From: Amanda Scholes <Amanda.Scholes@arun.gov.uk> **On Behalf Of** Planning.Responses
Sent: 14 July 2020 09:22
To: Planning Scanning <Planning.Scanning@arun.gov.uk>
Subject: FW: FW: FW: A/62/20/DOC - Pound Place, Roundstone Lane

The majority of points have now been adequately resolved. However, there a couple which require further work. Please see my comments below. I hope that we can get these remaining points resolved promptly.

DRAWING TITLE:
PROPOSED
IMPERMEABLE AREAS
SHEET 2

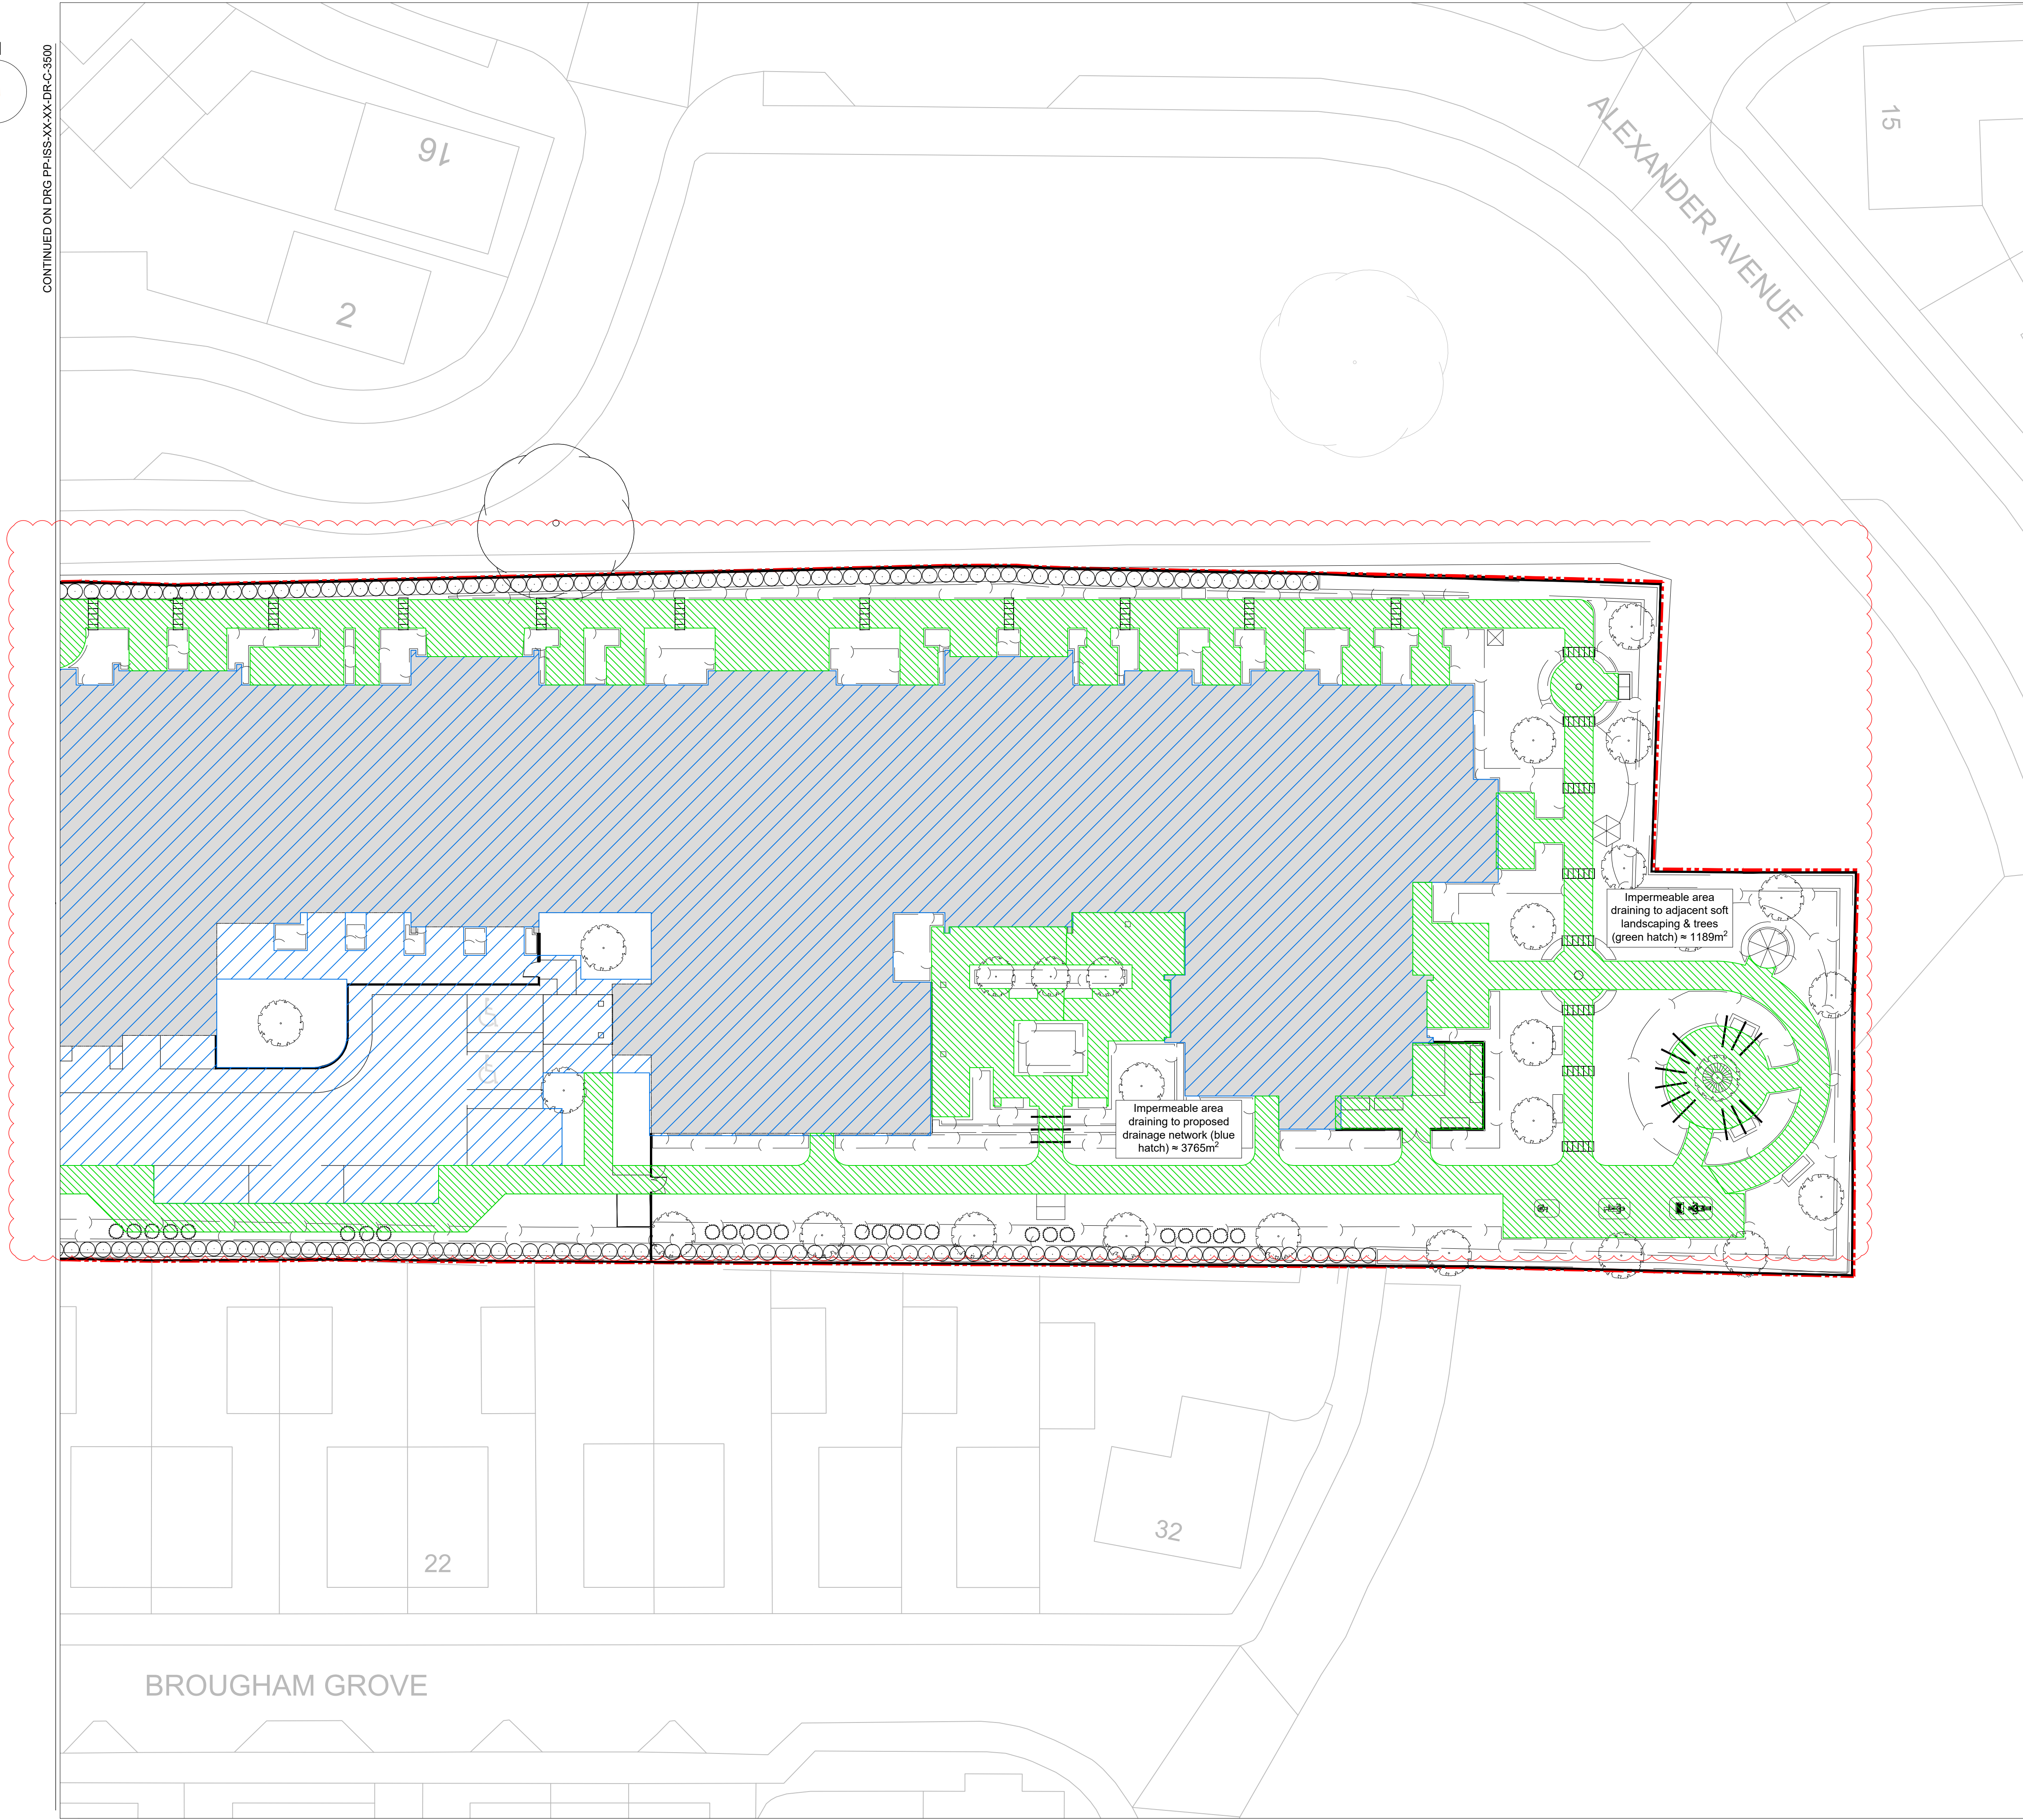
2. Please provide a revised catchment area plan. *Revised catchment plan provided (dwg PP-ISS-XX-XX-DR-C-3500 to PP-ISS-XX-XX-DR-C-3501)* Please break this down to areas going to each soakaway, rather than just providing total impermeable area for the site.
